Application Ref:	3/2026/0140			 Ribble Valley Borough Council www.ribblevalley.gov.uk
Date Inspected:	20/03/26	Site Notice:	20/03/26	
Officer:	LW			
DELEGATED ITEM FILE REPORT:				APPROVAL

Development Description:	Proposed demolition of existing dwelling and replacement with one new dwelling (self-build), outbuilding and garage.
Site Address/Location:	Rose Hill Farm, Whalley Old Road, Billington, BB7 9JF.

Project Name	Project No.	Stage
Rose Hill Farm	219.25	Planning Submission
Proposed Site Plan		
07	Scale	1:500 @ A1
	Date	January 2026
Rev --	Drawn	RP

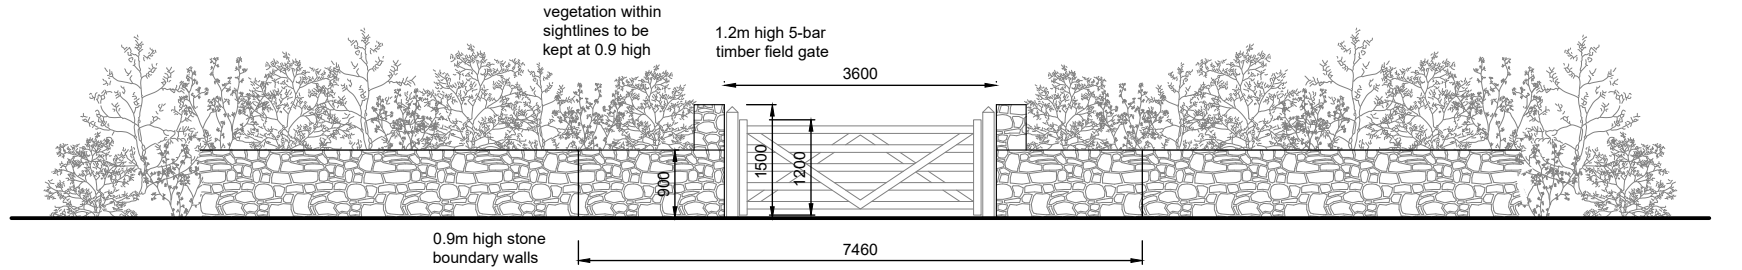
The proposal originally submitted with the application included a new access track which extended approximately 140m between Whalley Old Road and Rose Hill Farm, with a width of 3.8m, winding through the centre of the of the field, along with 0.9m high stone walls and a gate at the entrance. Whilst it was acknowledged that the gravel geogrid system track with a central verge would appear somewhat agricultural in appearance, the length and position of the track and associated hard surfaced entrance and stone walls was considered to intensify and urbanise the site which is currently an undeveloped grassland accessed via a modest field gate. The proposal would thus result in a fundamental change to the character of the field and a loss of openness in the Green Belt.

In addition, the originally proposed access track and associated entrance walls and gate would have introduced a visually intrusive feature across the open field to the south of the dwelling. Due to the topography and public vantage points, these elements of the scheme would have been visually prominent, resulting in a harmful urbanising effect and eroding the rural qualities of the landscape.

The scheme as originally submitted included the formation of a new vehicular access onto Whalley Old Road. The Highway Authority advised that the access would require works to be secured through a legal agreement and constructed to an appropriate specification. However, this element has been removed from the amended scheme, and the development will instead utilise the existing access arrangement which serves the dwelling and several other residential properties. As such, no highway works are required in association with the proposal.

Project Name	Rose Hill Farm	Project No.	219.25	Stage	Planning Submission
Proposed Floor Plans	09	Scale	1:100 @ A1	Date	January 2026
Rev	E	Drawn		RP

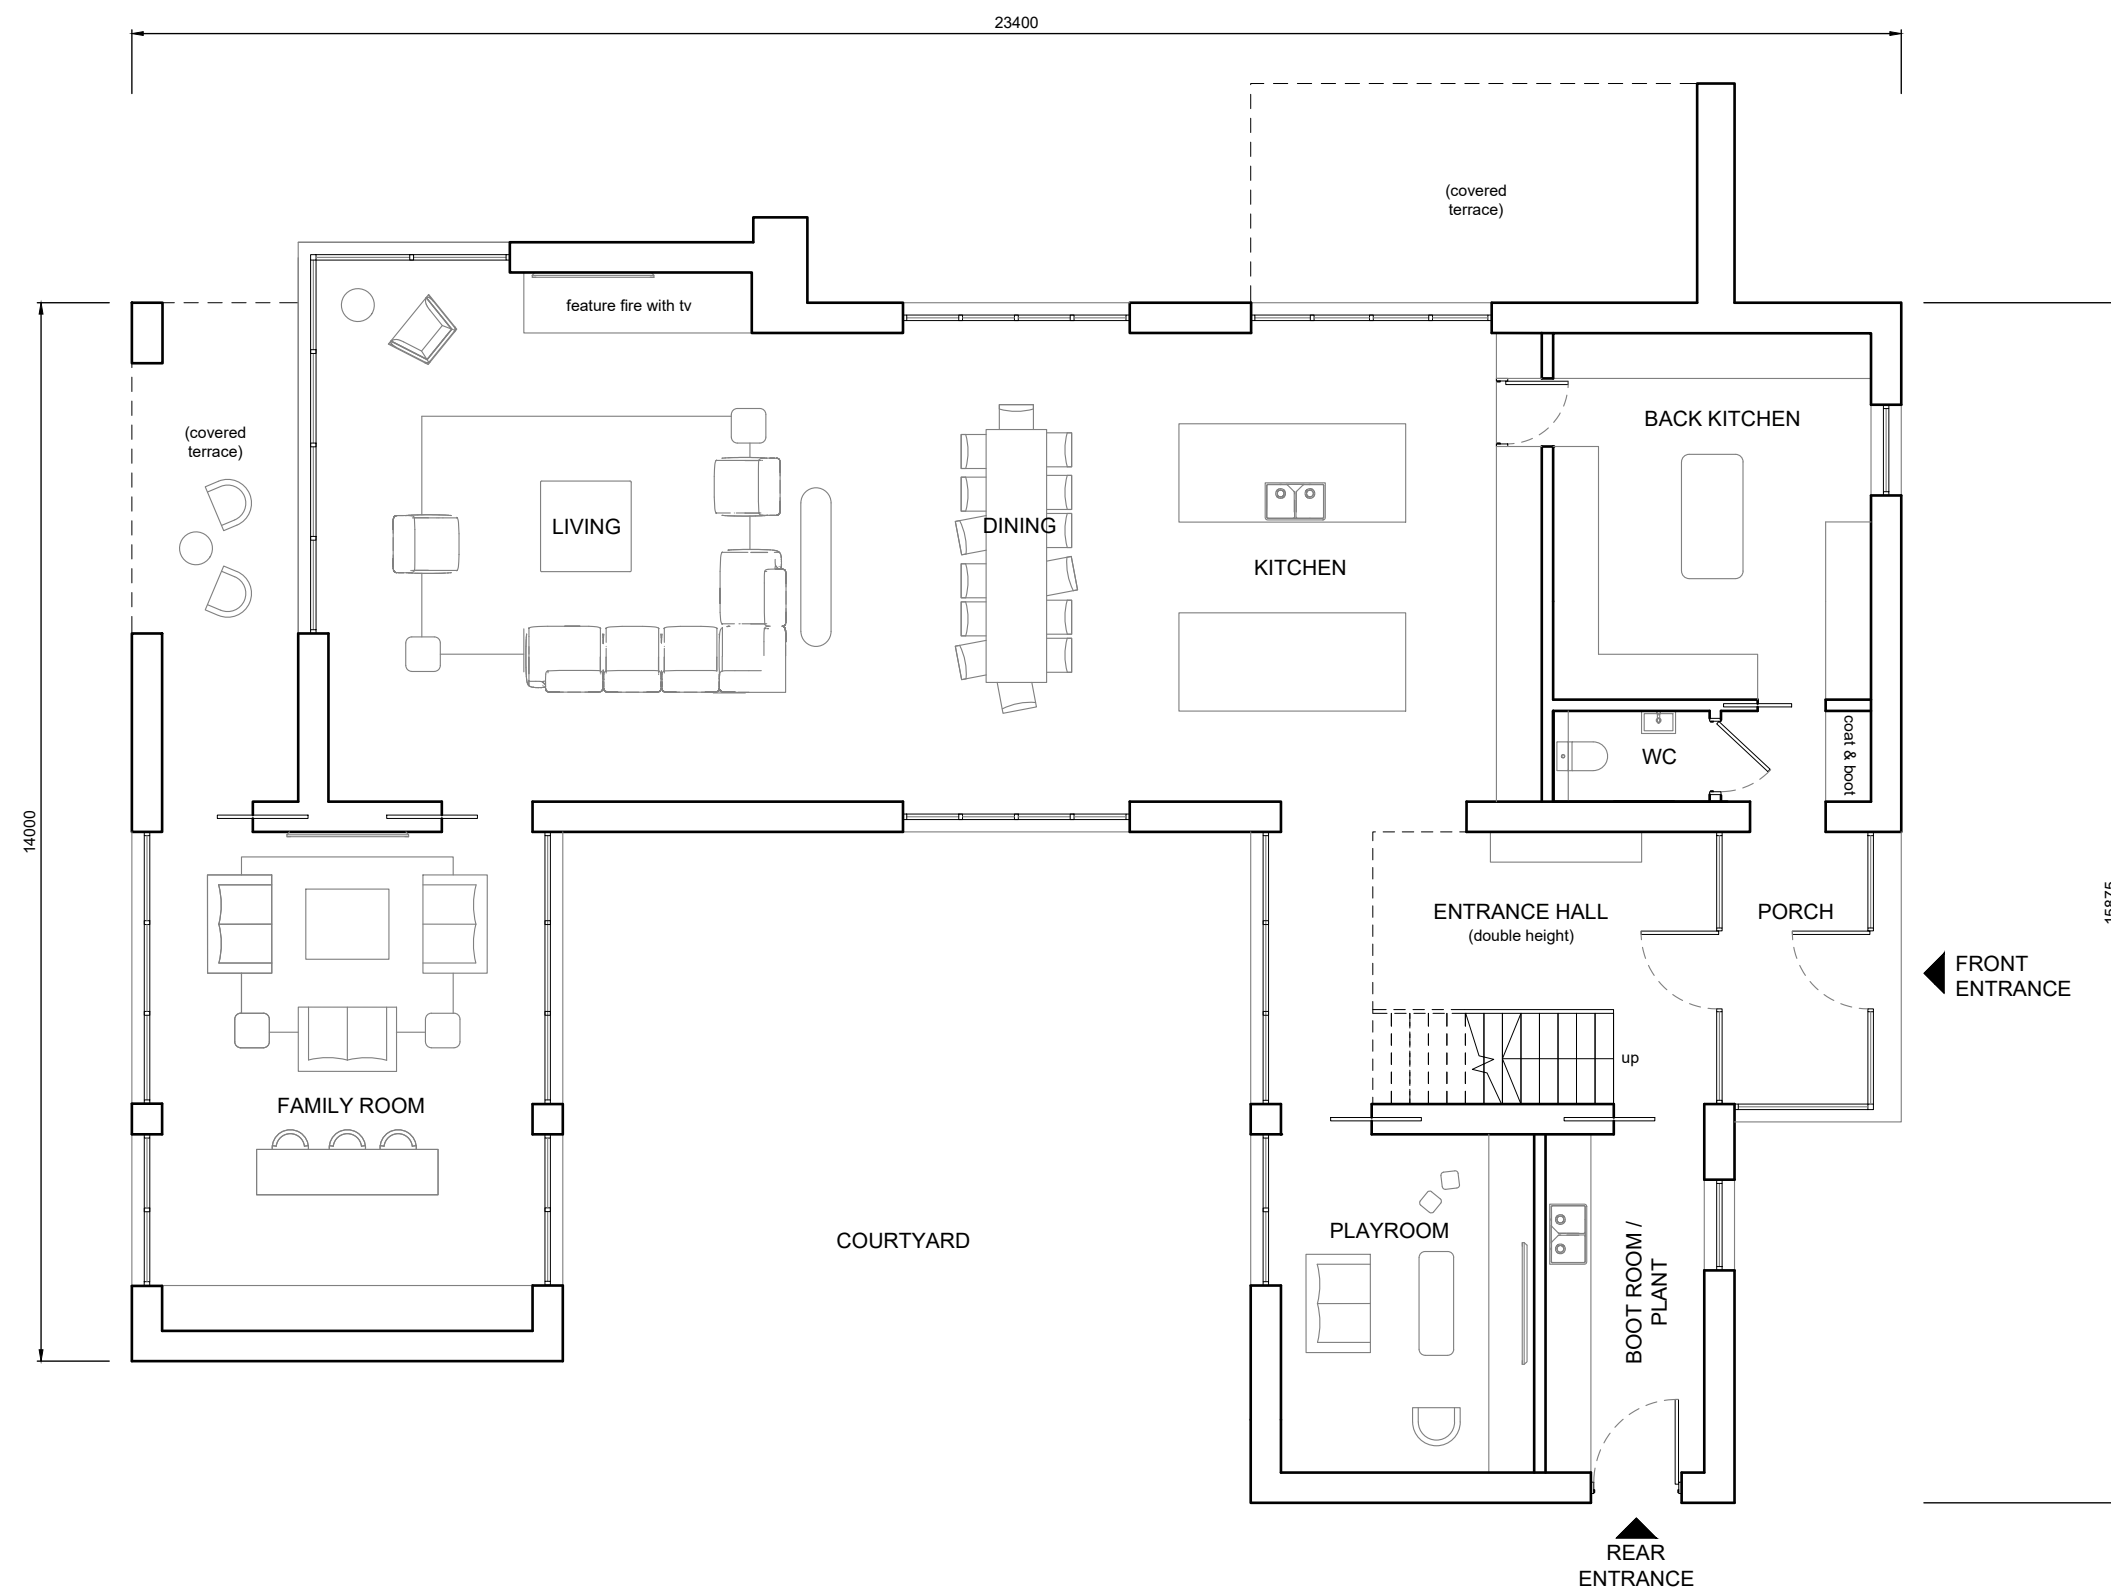
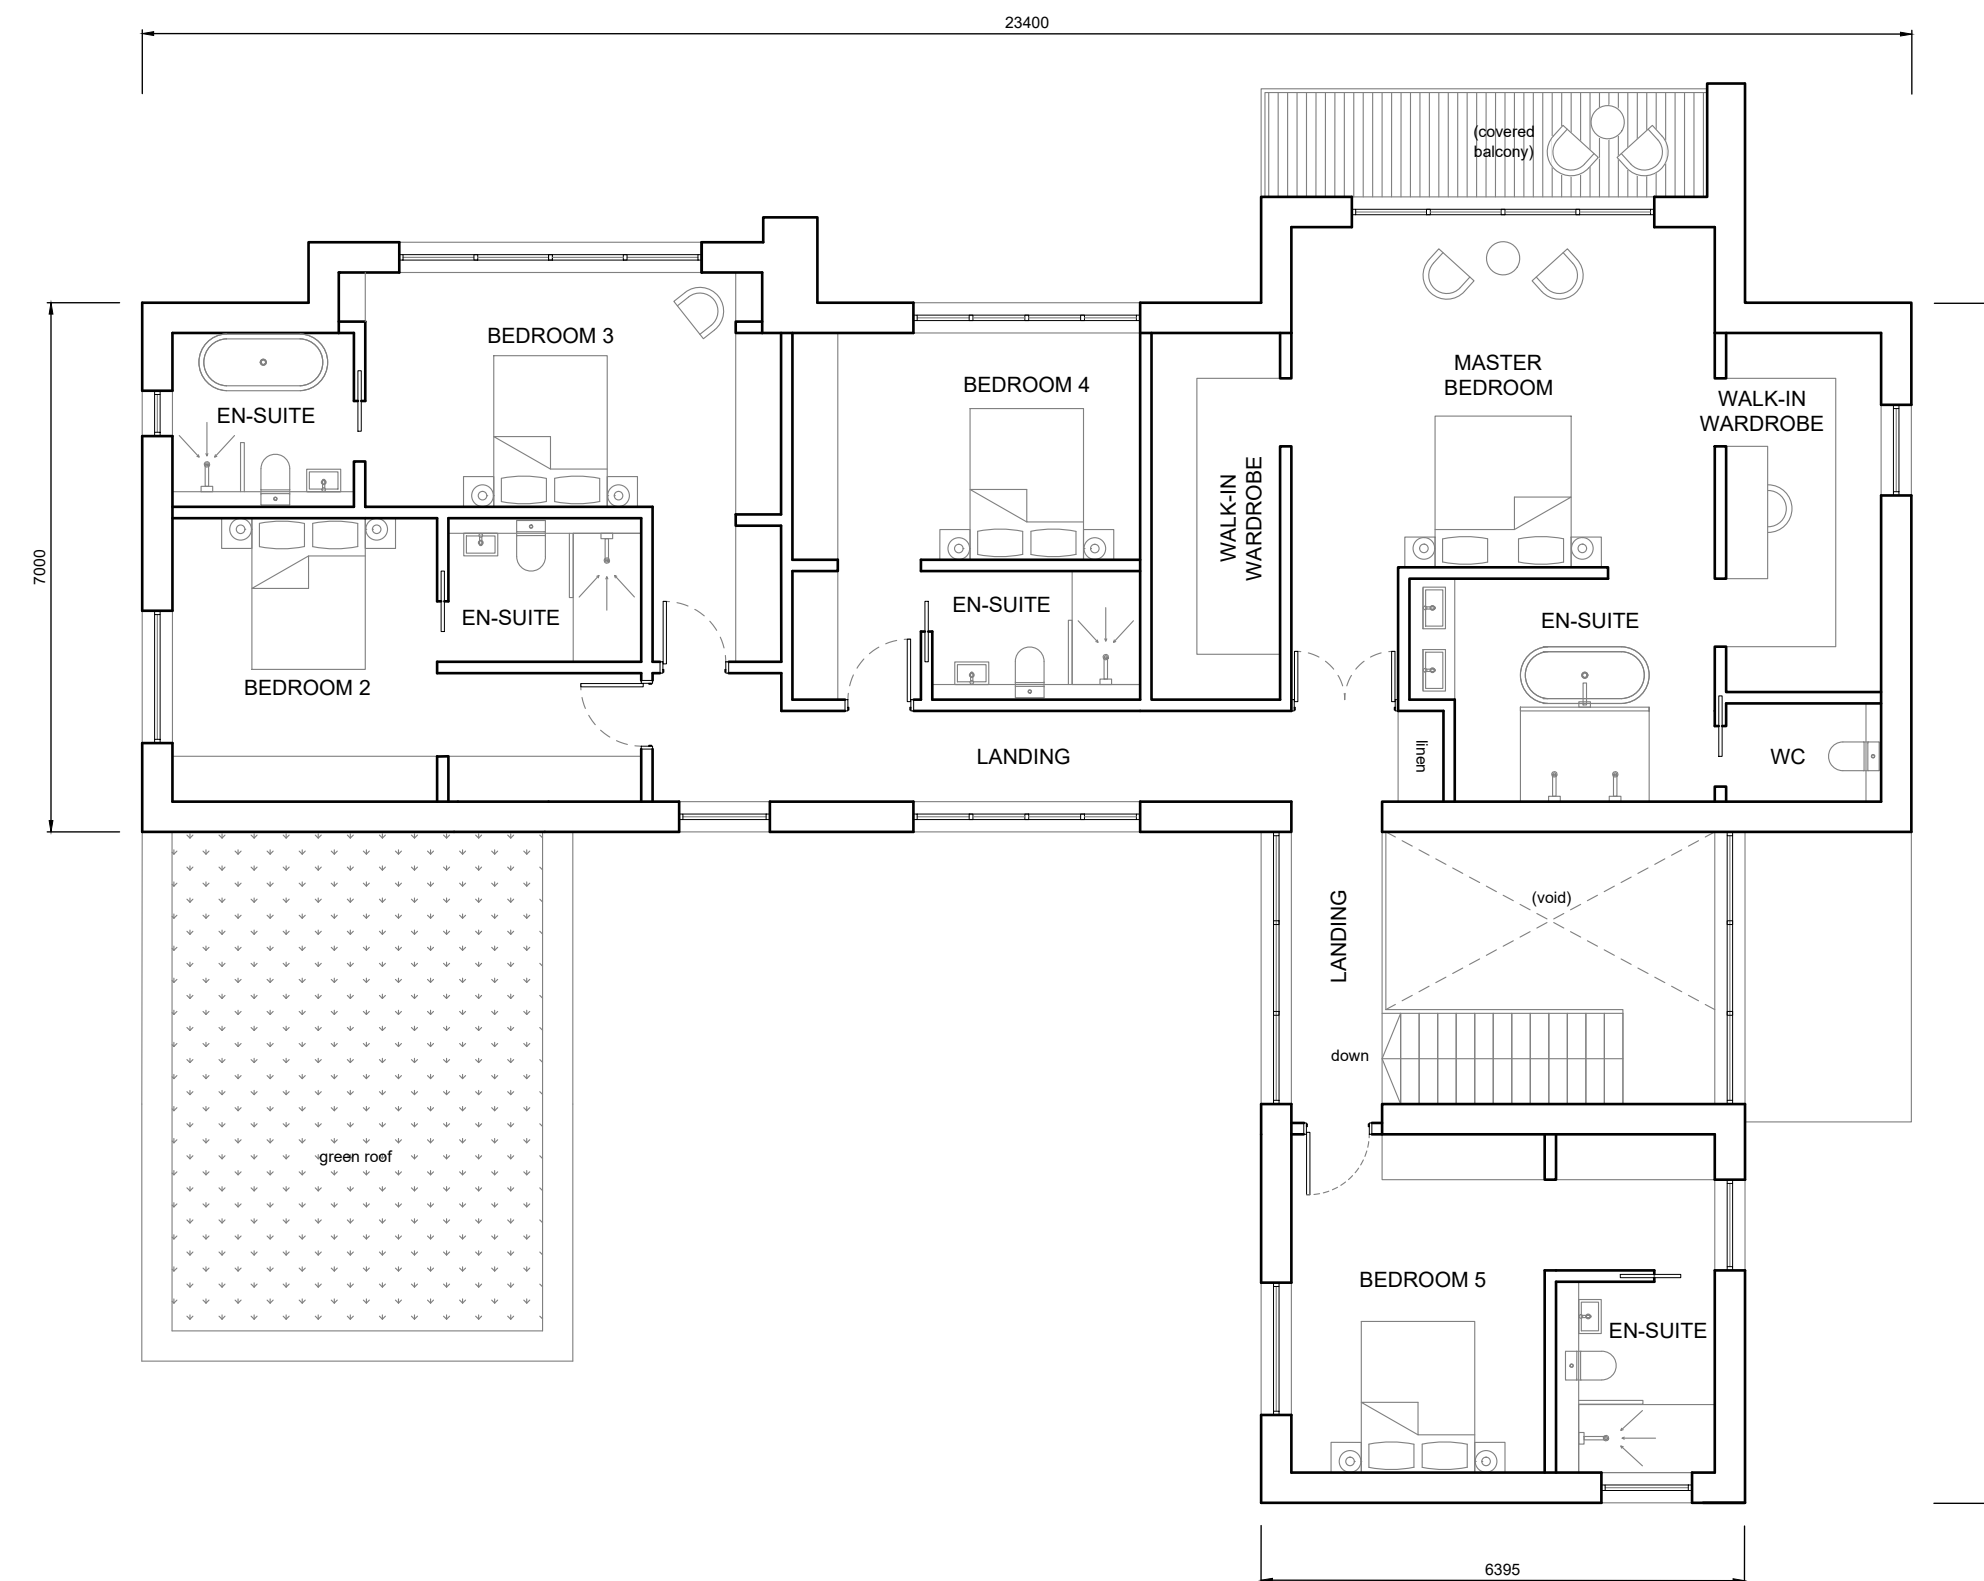
The amended dwelling has been reduced in overall scale and massing, resulting in an approximately 23% increase in volume when compared to the existing building. Importantly, this increase would be considerably less perceptible than that proposed under the previous scheme. The projection of both wings has been reduced, including the removal of the previously proposed flat-roofed link elements. Furthermore, the pitched roof formerly proposed over the single-storey wing has been replaced with a flat green roof, further reducing the visual impact of the development. The associated outbuilding has also been scaled down and redesigned as a simpler linear form, resulting a more restrained and subordinate appearance.

As mentioned above, the scheme has been amended since initial submission and adopts a more coherent and balanced architectural approach, with a clearer hierarchy of built elements. The overall massing has been consolidated into a more compact form, reducing visual spread across the site.

The palette of materials has also been rationalised, with natural stone serving as the primary material and timber cladding used more sparingly which better reflects the local vernacular whilst still incorporating some contemporary detailing. The two feature rooflights have also been omitted.
